Ribble Valley Borough Council
Housing & Development Control

Application no: **3/2023/0197**

Address: **Keepers Cottage Northcote Road Langho BB6 8BD**

Proposal: **Approval of details reserved by conditions 4 (Landscaping Plan), 10 (Construction Management Plan), 17 (Foul and Surface Water) and 20 (Details of heat pump) of planning permission 3/2022/0637.**

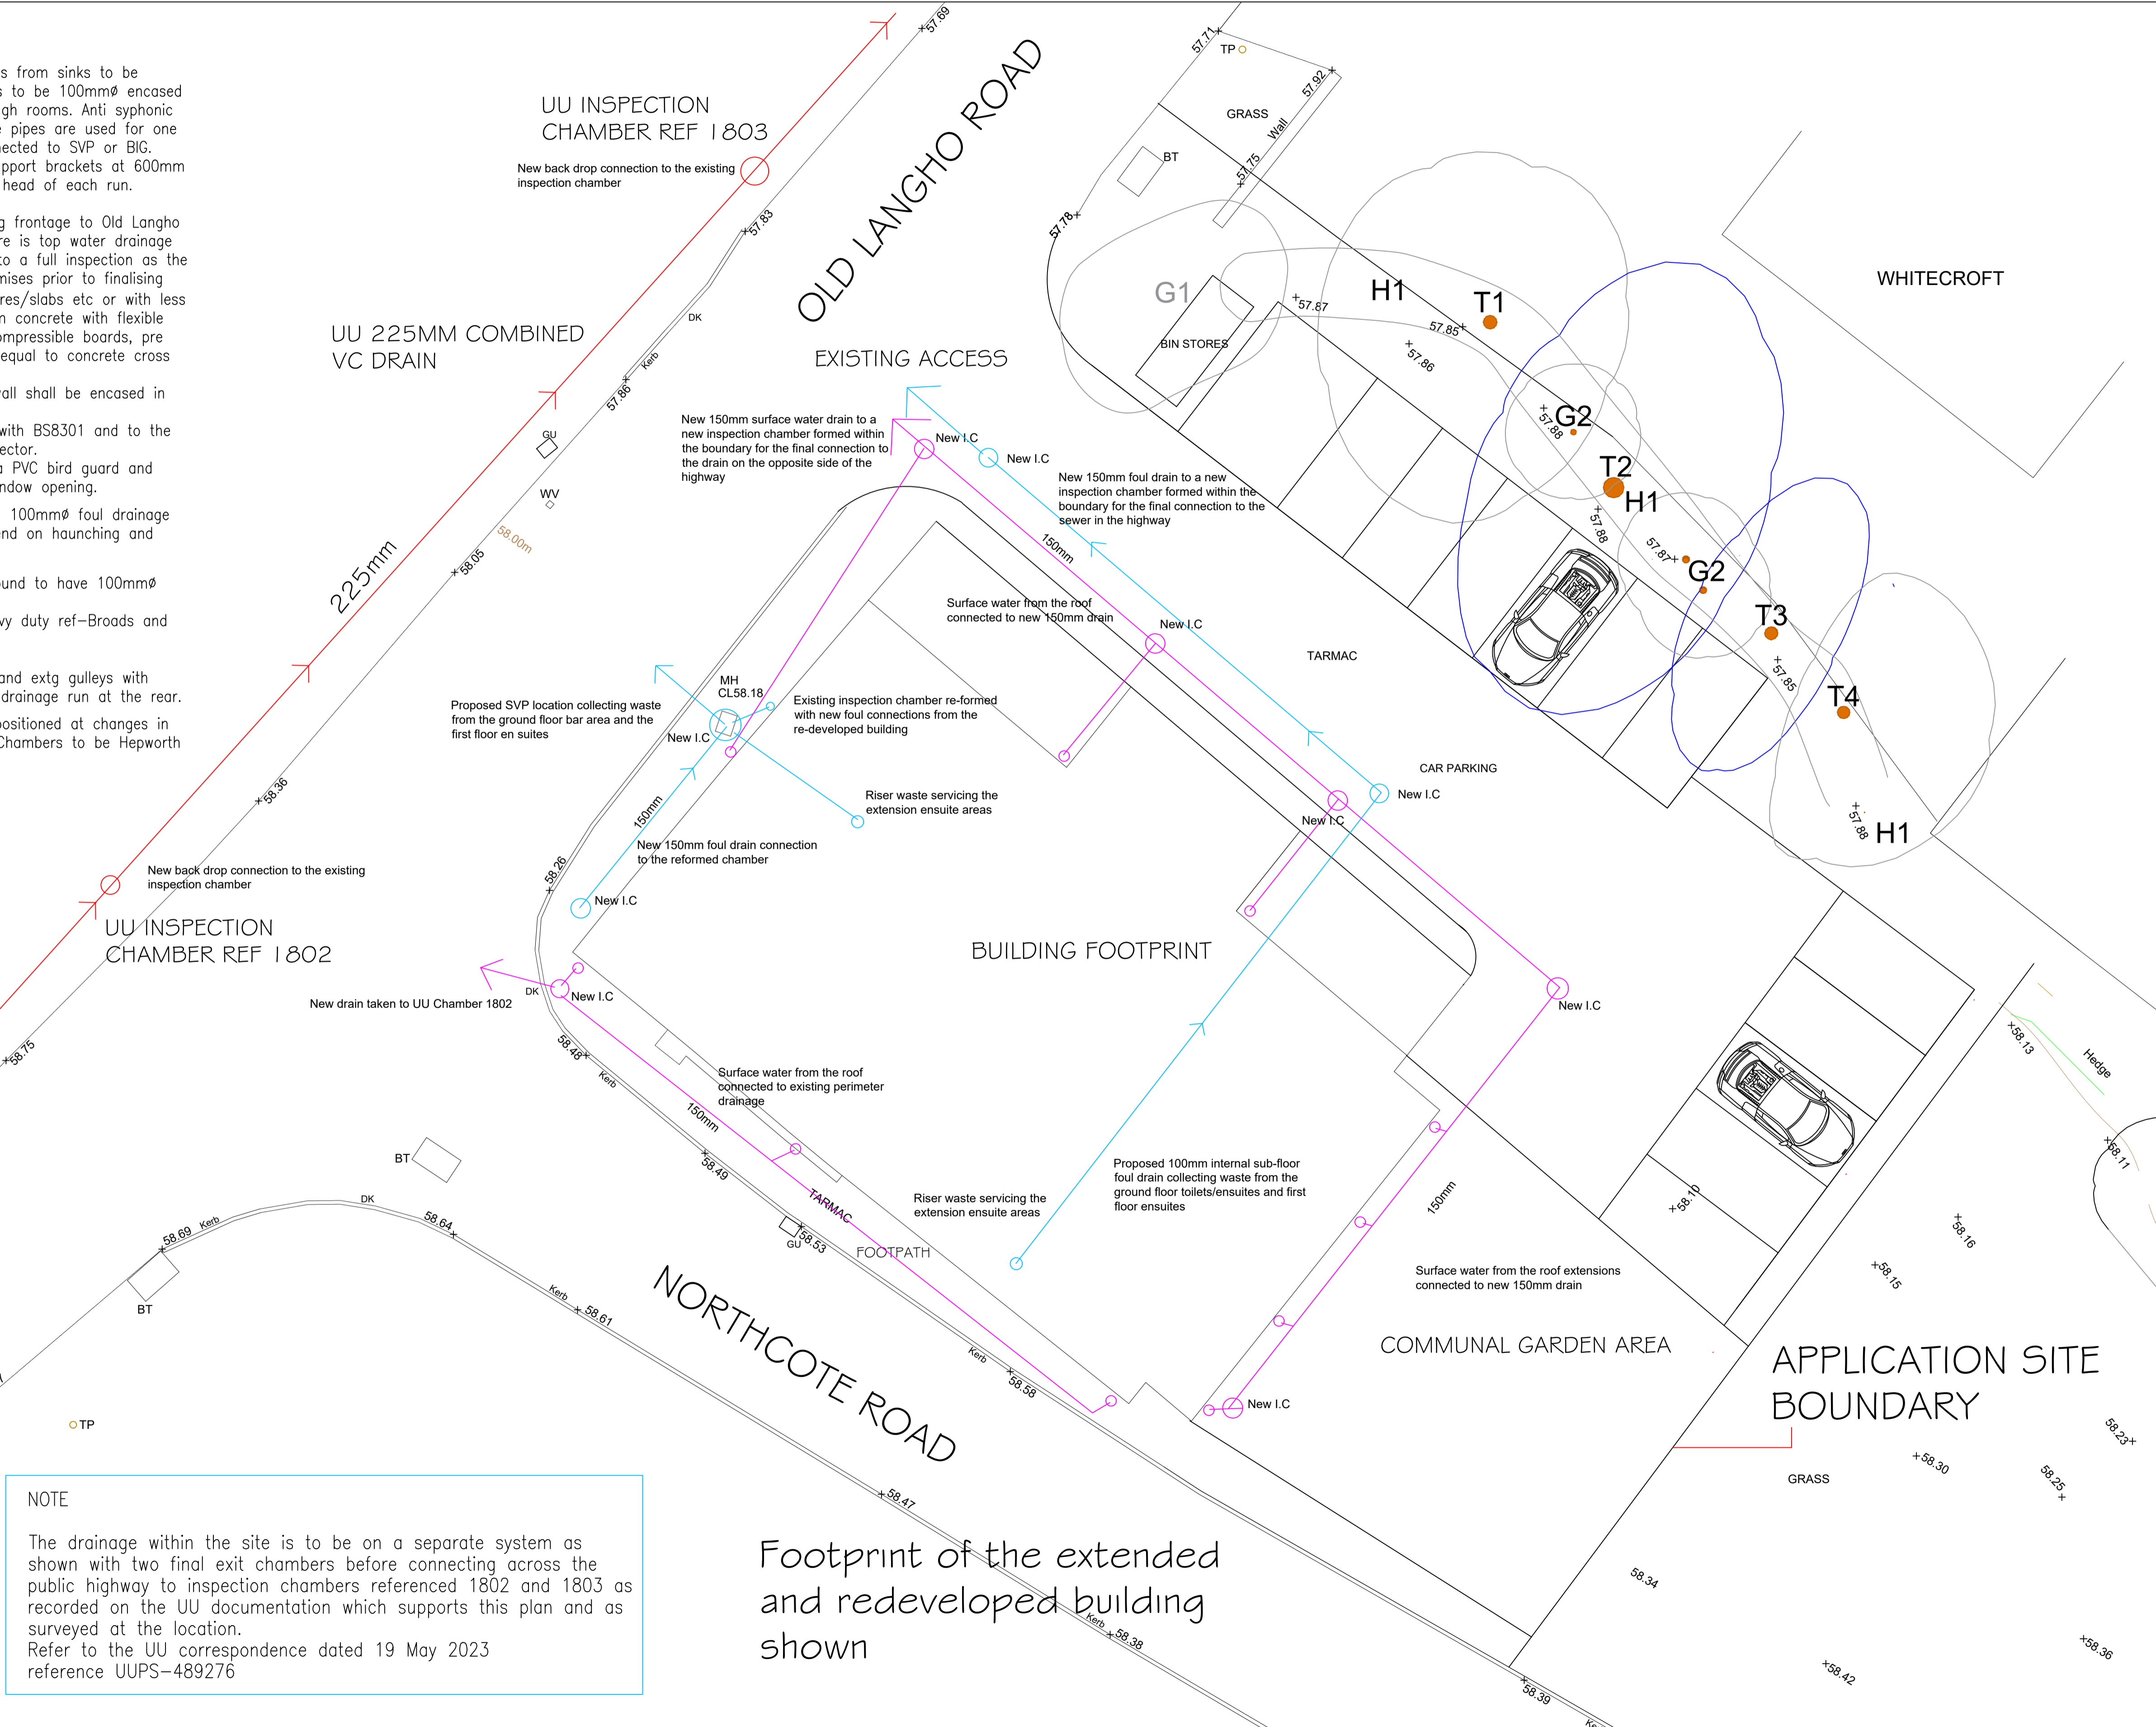
The LHA have reviewed drawing number 5000 titled "Drainage Strategy Plan" and require further information regarding where the new 150mm surface water and 150mm foul pipes will drain to. This because the LHA are unable to accept these pipes connecting to any highway owned drains or gullies.
